Rezoning Transportation Analysis
Petition Number: Insert Zoning Petition #2021-207
General Location Identifier: 15902801

Revision Log:	Date	Description
	01/21/2022	First Review (WB)

CONDITIONAL NOTES:

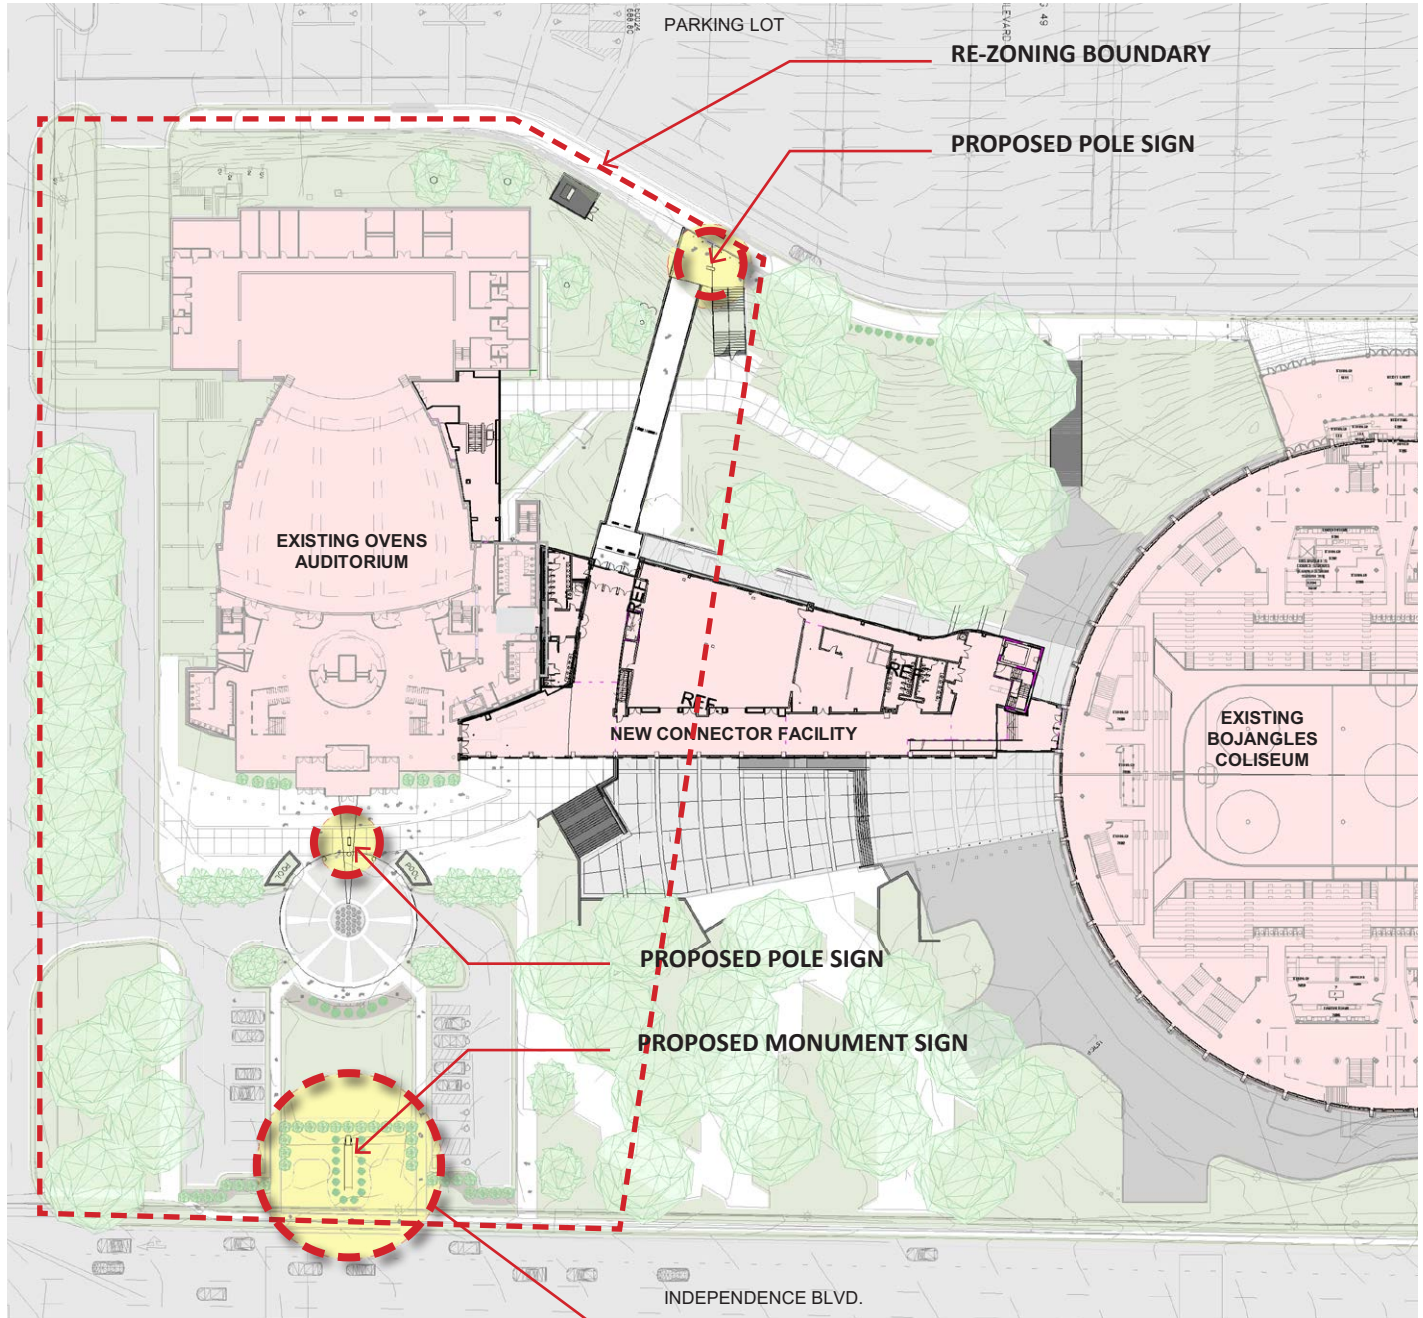
3. Add a conditional note to commit to obtaining a permit with the NCDOT Outdoor Advertising Unit prior to construction. (Mason Thompson is the NCDOT contact).
4. Add the following conditional note, "All public roadway improvements will be subject to the standards and criteria of CDOT and NCDOT, as applicable, to the roadway improvements within their respective road system authority. It is understood that such improvements may be undertaken by the Petitioner on its own or in conjunction with other development or roadway projects taking place within the broad central Mecklenburg area, by way of a private/public partnership effort or other public sector project support."

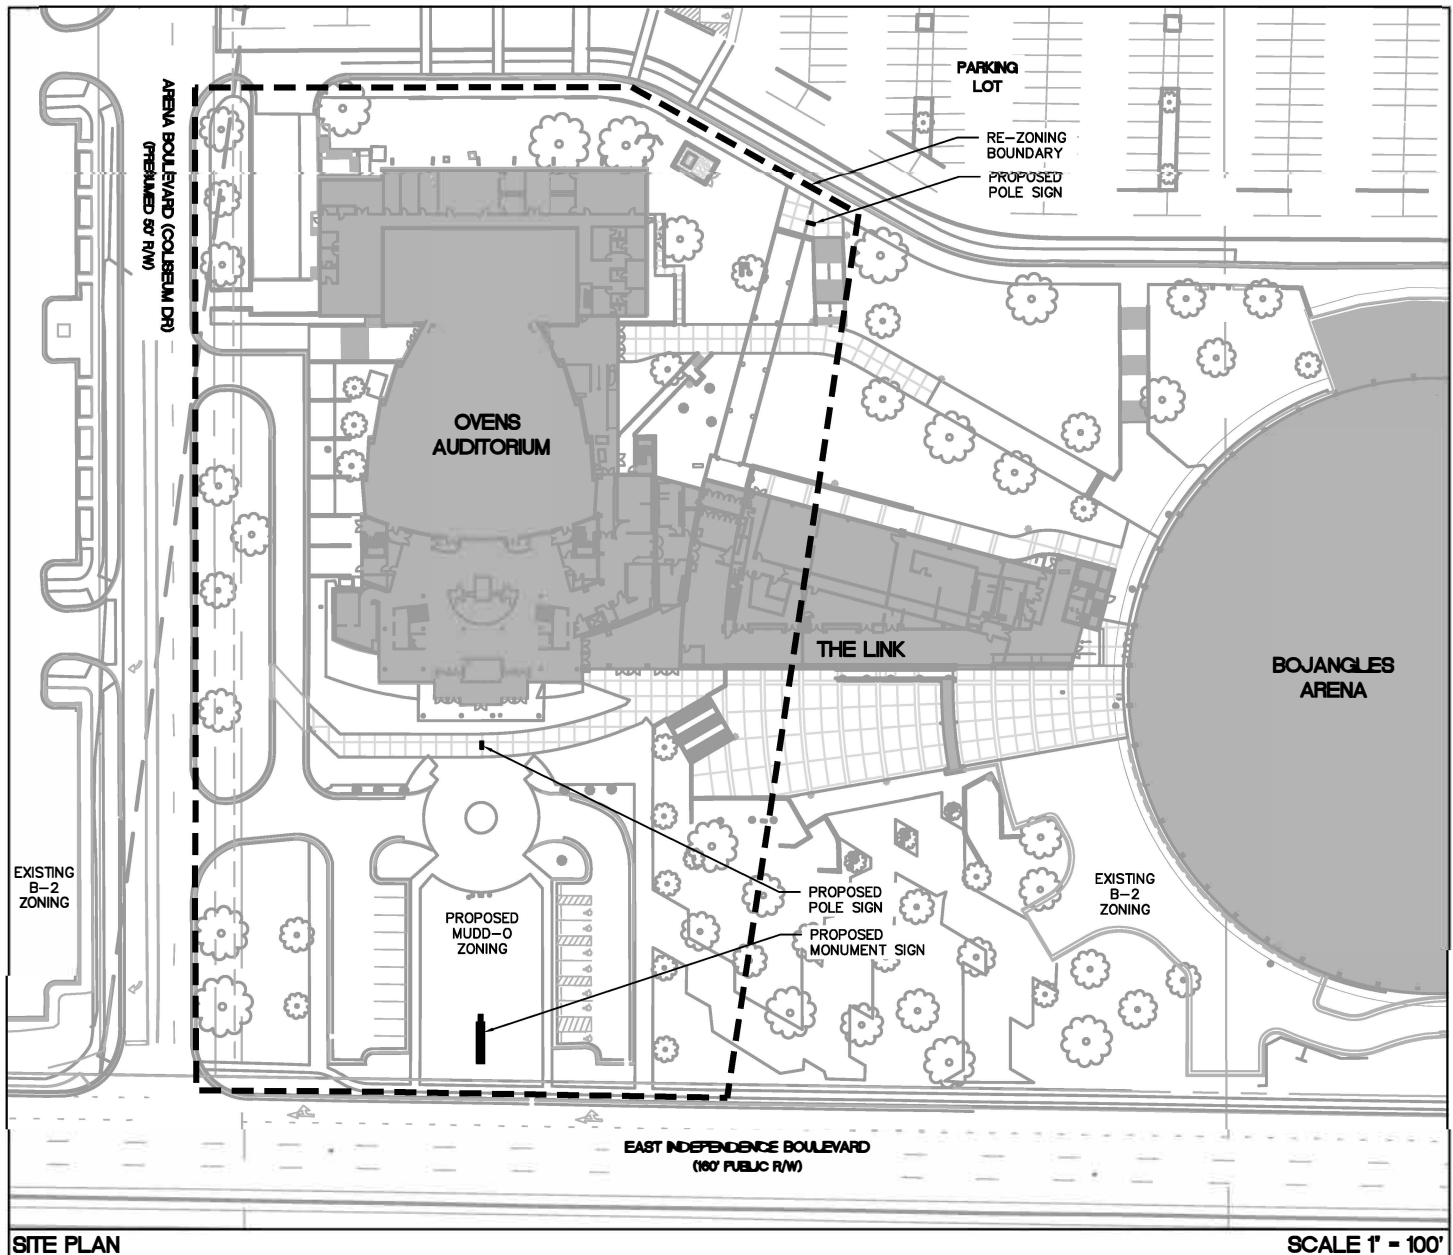
1. **Curbline:** The proposed zoning district has a setback measured from back of the existing or proposed future curbline.
 - a. **Independence Blvd:** The future location of curb and gutter is in its existing location.
 - b. **Coliseum Drive:** The future location of curb and gutter is in its existing location.

Label and dimension the curb and gutter from the centerline for each road on the site plan.
